Item No.	Report of the Head of Development Management and Building Control	
Address:	26 WINDSOR AVENUE HILLINGDON	
Development:	Part single; part two-storey rear extension to the host dwelling (following demolition of rear extension); part single part two-storey side/rear extension to form an attached new dwelling (following demolition of side extension); raising of overall ridge height; removal of front gable to host dwelling; sub-division of site; hard and soft landscaping; boundary treatment; new vehicular crossover including alterations to the existing parking provision and refuse/cycle storage (amended description)	
LBH Ref Nos:	75963/APP/2024/1397

Drawing Nos:	20/028_S1 20/028_P1 20/028_P3 20/028_S0 20/028_P2 20/028_P1 20/028_S3 20/010_P4 20/028_P0 20/028_P0L 20/028_S1 20/028_S2 20/028_S4 20/028_S5	
Date Plans received:	24-05-24	Date(s) of Amendments(s):
Date Application valid	24-05-24

Scale: 1:100 @ A3 FEB 2025 Dwg. 20/028_P0

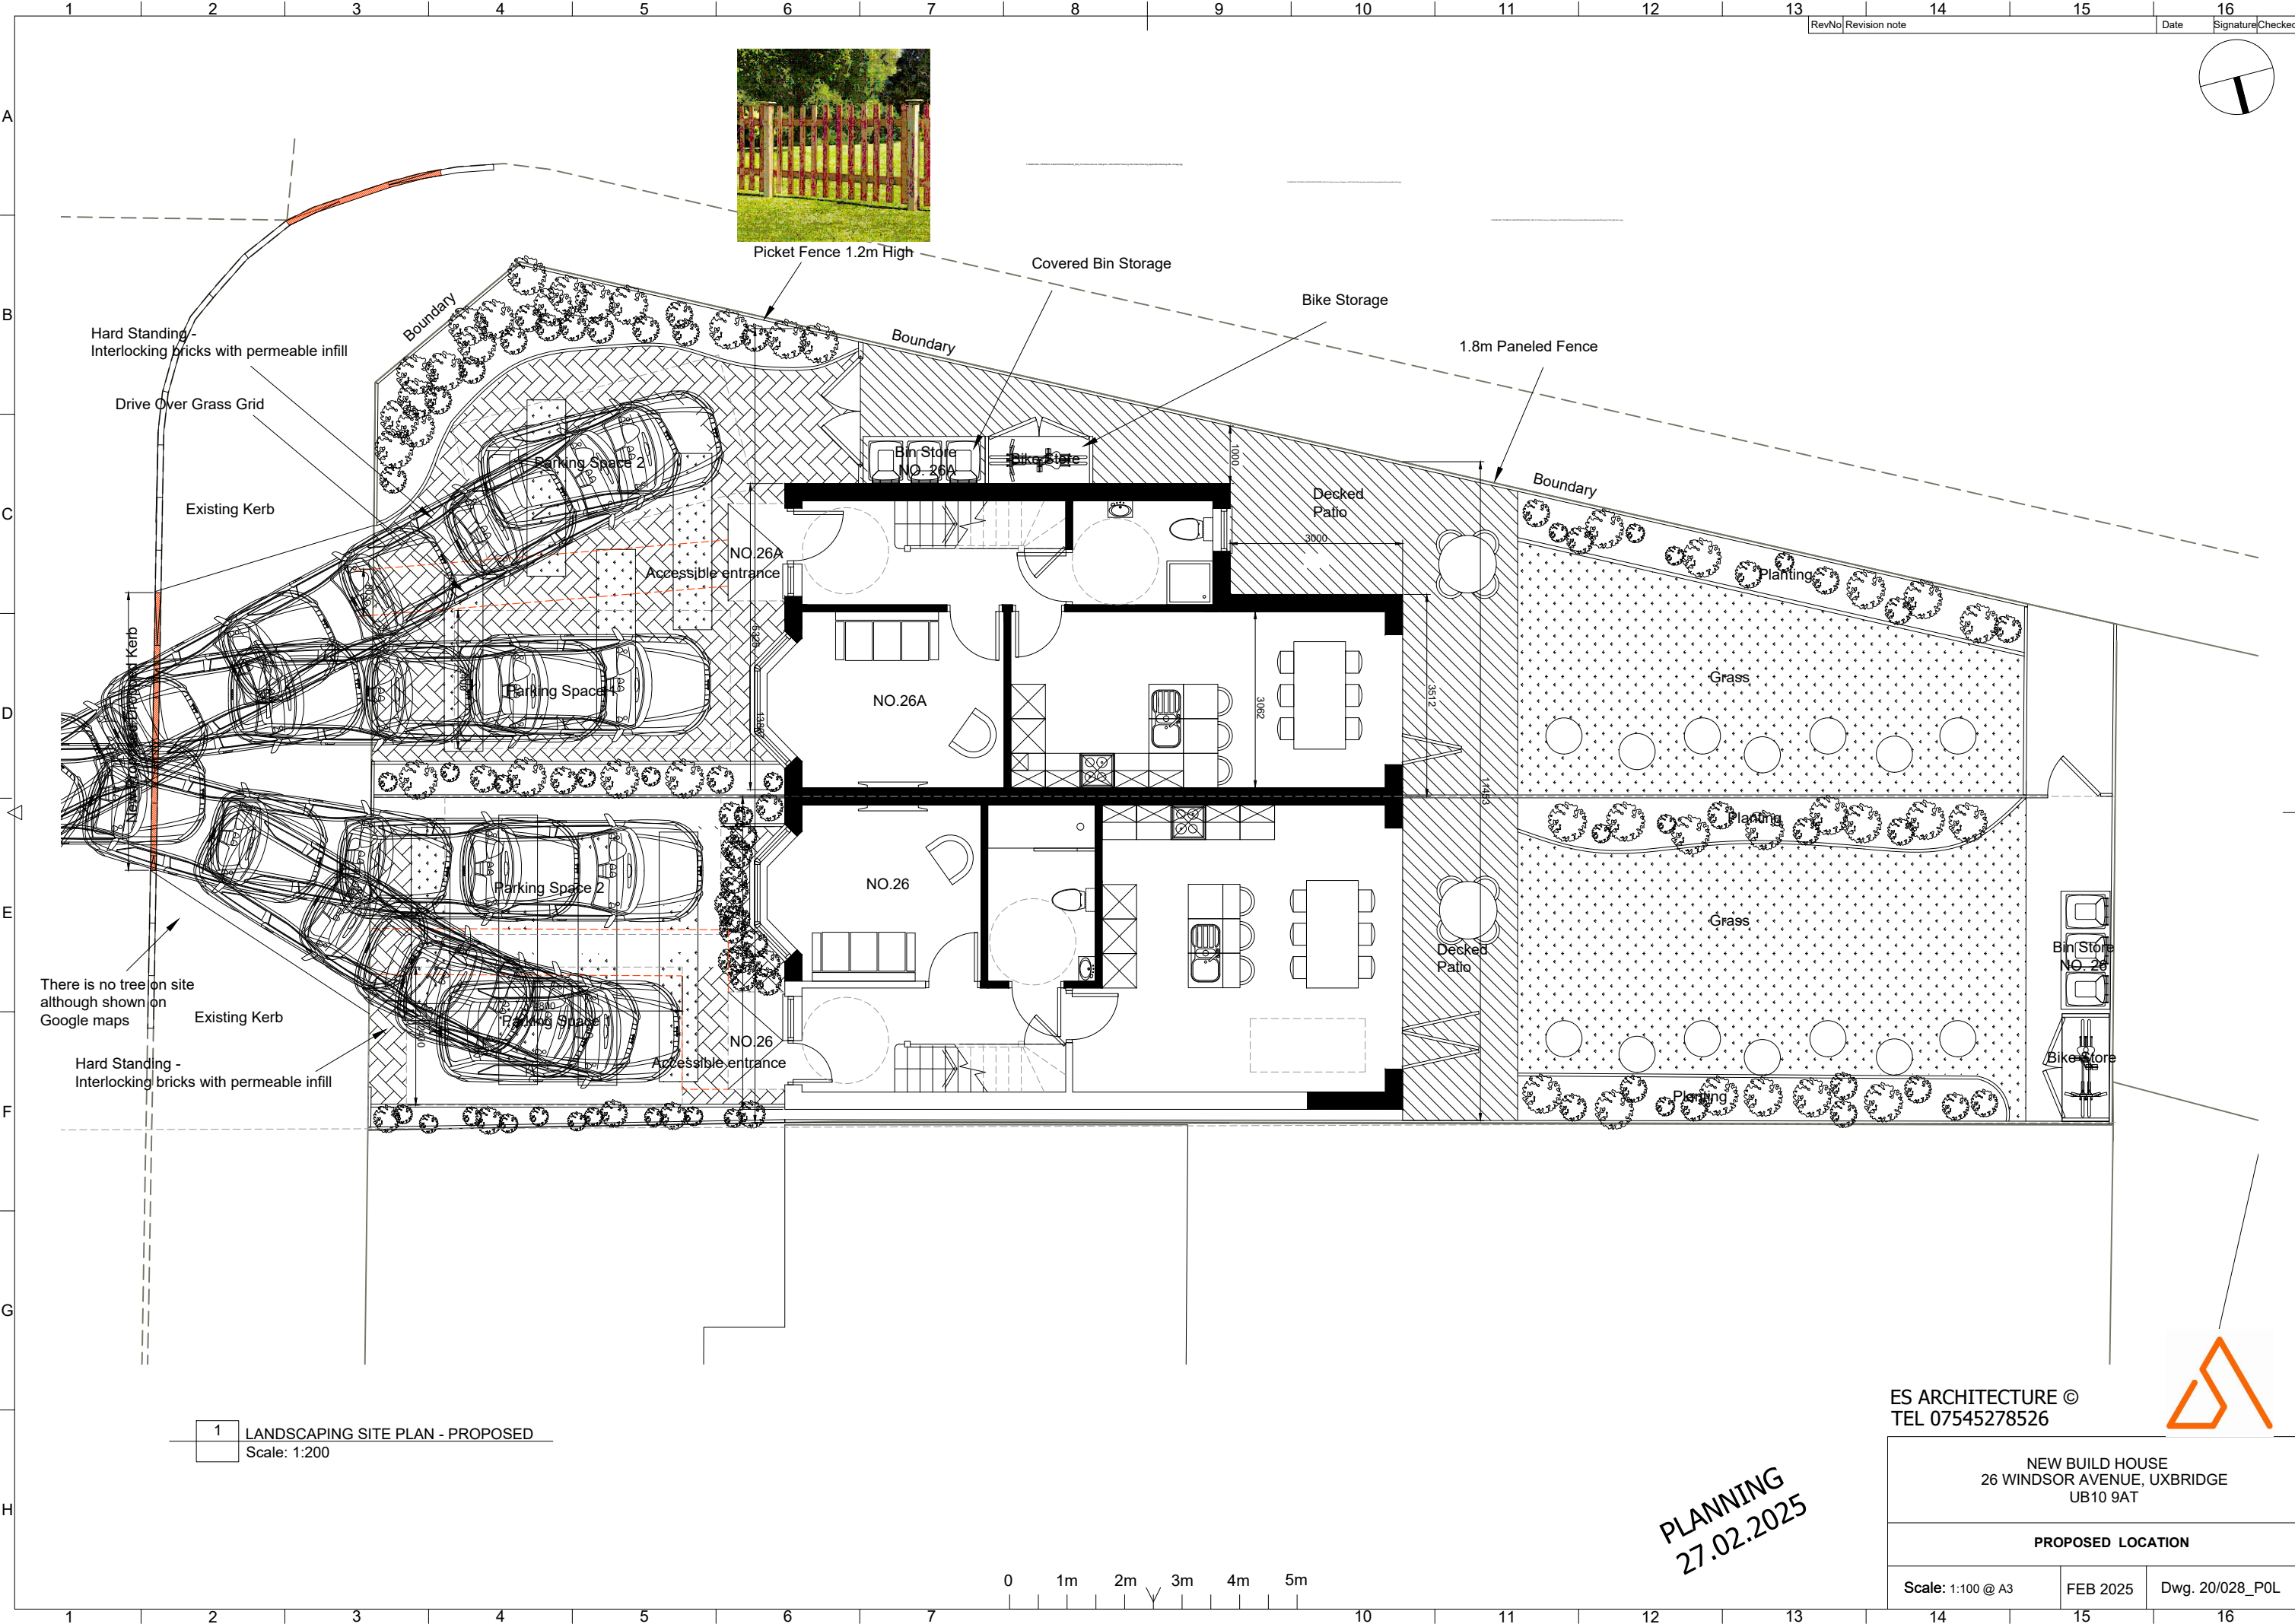
The Highway Authority is concerned that the application is invalid as the red line and blue line of the application site have been drawn incorrectly as shown in Drawing 20/028_P0 titled Proposed Location.

Drawing 20/028_P0 titled Proposed Location shows the new dwelling outlined in blue and the existing dwelling in red. This should be amended to both be outlined in red.

1 GROUND FLOOR PLAN - PROPOSED
Scale: 1:100

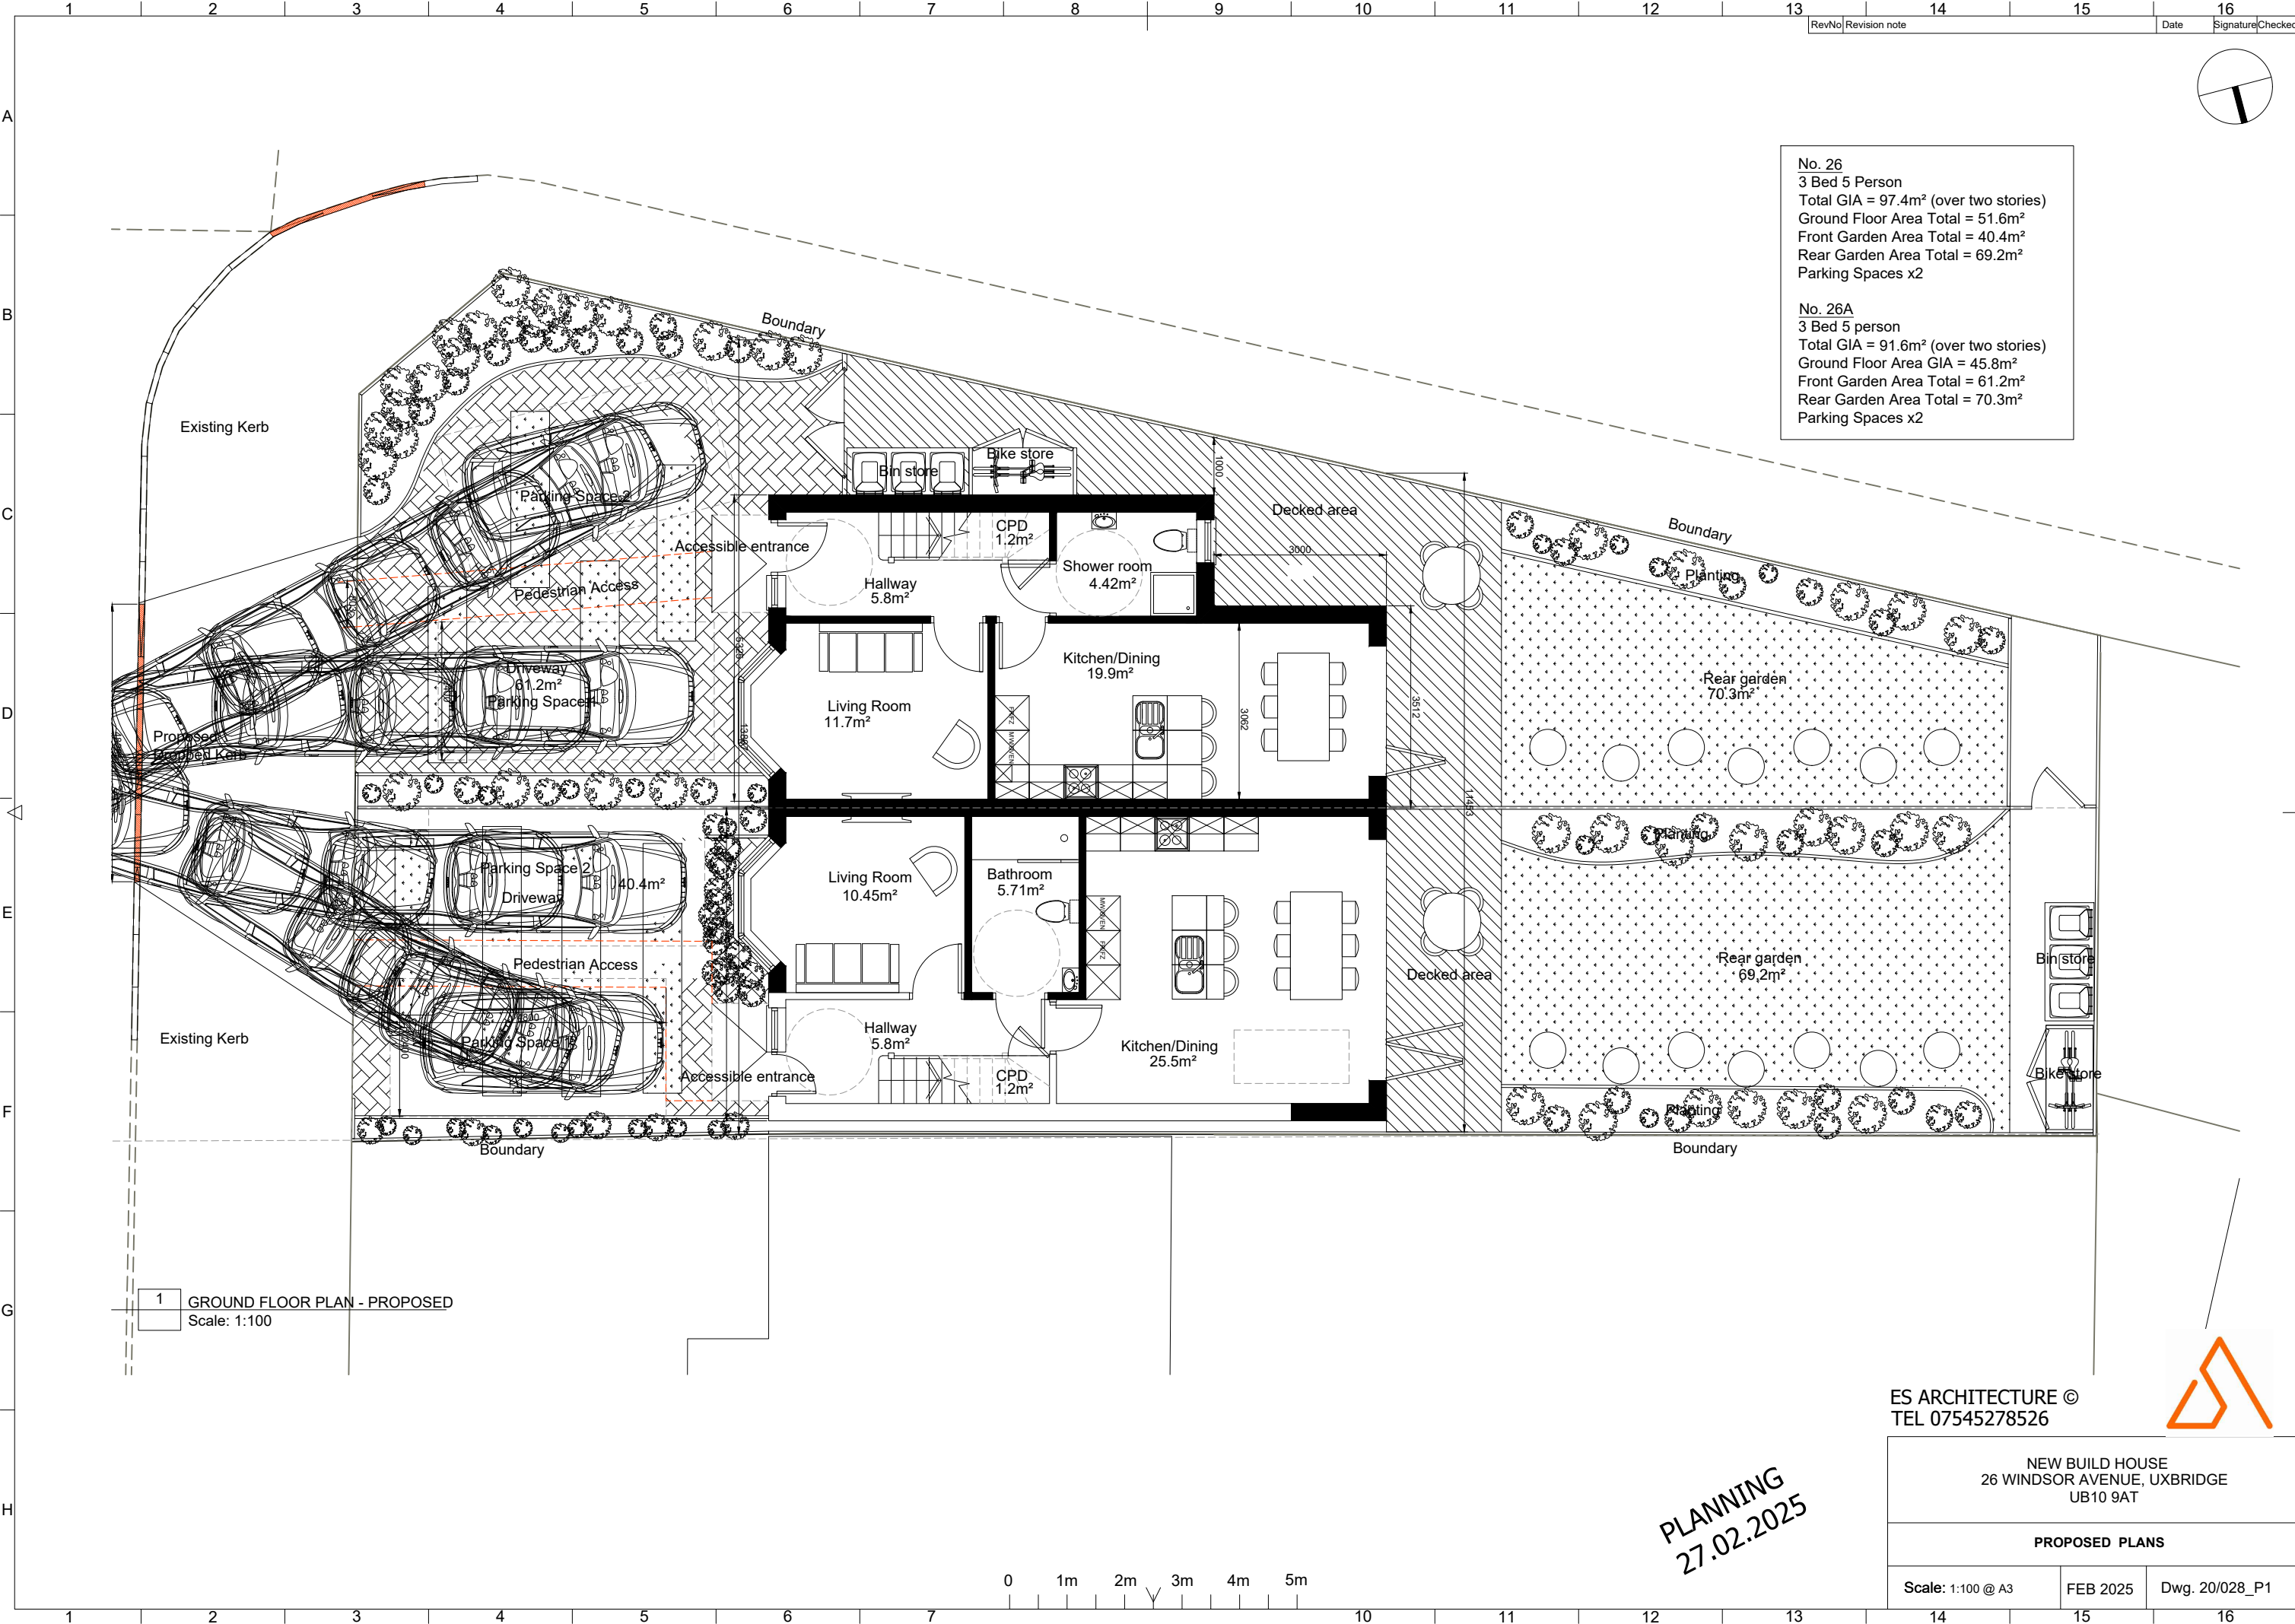
The proposed dwellings would be classed as 3 bed 5 person dwellings given the size of the bedrooms. Policy D6 of the London Plan (2021) requires that 3 bedroom properties with an occupancy level of 5 should have a minimum GIA of 93sqm with 2.5sqm of built in storage. The dwelling at no.26 would have a GIA of approx. 97sqm which would meet this requirement. However, the new dwelling (no.26A) would have a GIA of approx. 91sqm which is under the required amount which would leave future occupiers to have a poor level of internal living accommodation to the detriment of their amenities.

As such the proposed development would be contrary to Policy D6 of the London Plan (2021) and Policy DMHB 16 of the Hillingdon Local Plan (2020).

FRONT ELEVATION - PROPOSED

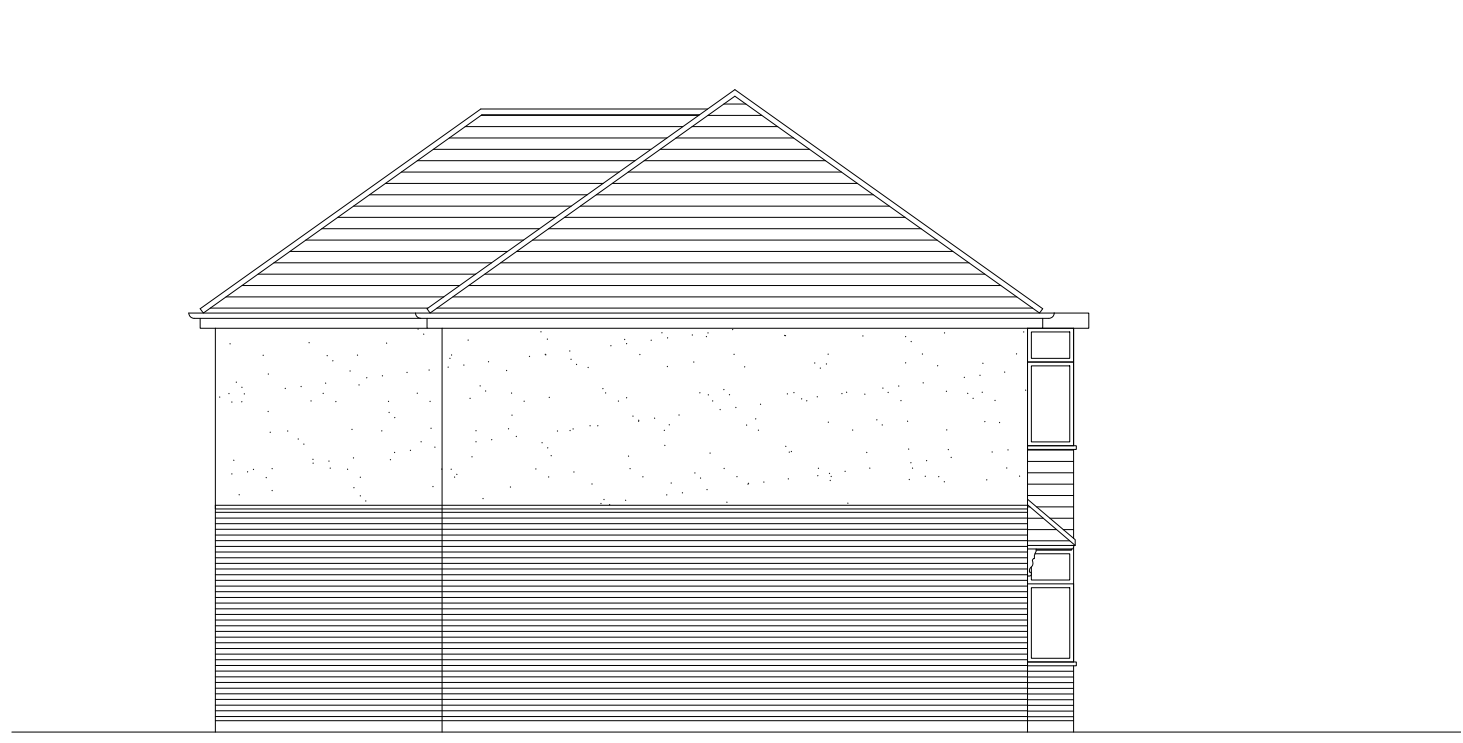
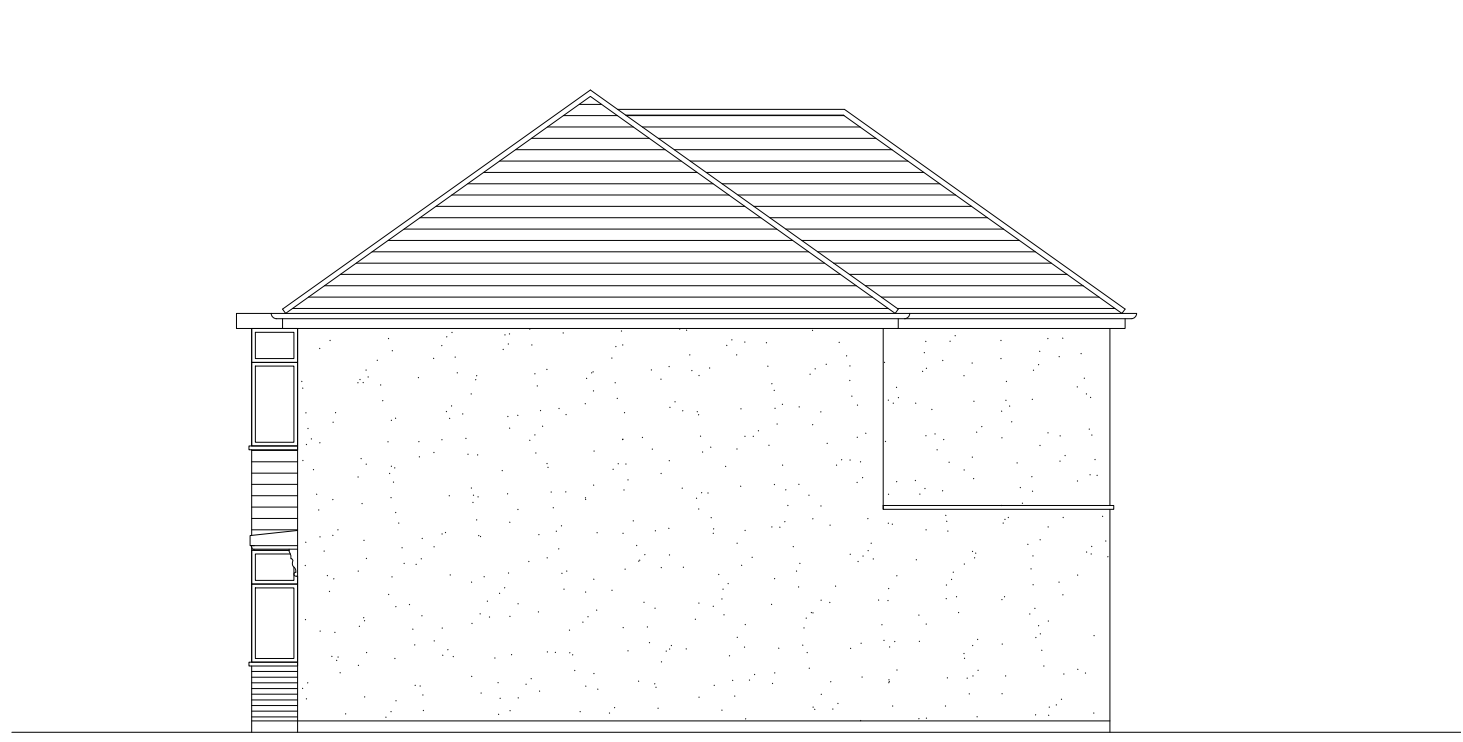
As noted within the previous case officers report 'In order to accommodate the proposed semi-detached pair, the host dwelling would have to lose its characteristic front gabled feature (noting no.28 does not have this) and be reduced in width by approx. 0.7m. This would result in the host and proposed dwelling appearing overly narrow and elongated when viewed in isolation with the properties along this part of Windsor Avenue and especially the subject corner plots of reference - no.2, 28, 50 and also no.48 and 70 of which have historically constructed extensions to form new attached dwellings. This lack of proportion would be exacerbated by the raising of the roof ridge. The works undertaken to the host dwelling as an initial stage of the proposal would detriment the form, proportions and appearance of the dwelling as viewed within the street scene'.

The proposed development would form a pair of semi-detached properties identical in form to each other. However in doing so the development would lose the character and appearance of the existing property and would appear cramped within its plot. The site is at an angle where the development would be approx. 2.7m away from the boundary at its widest point however at its narrowest points would be sited only 1m away from the boundary. Whilst in parts, the proposal would retain larger gaps, the overall combined siting, height, width and depth of the proposed dwelling would be overly close and as such result in the development appearing too cramped and dominated in its setting. Given its corner plot position the development would be readily seen from multiple vantage points and would close the openness of the plot significantly.

by approx. 0.5m. A street scene elevation drawing has not been provided to show how the development would integrate with the surrounding properties. As such, it cannot be concluded what impact this would have on the surrounding area. Any future application should be accompanied with existing and proposed street scene elevation drawings.
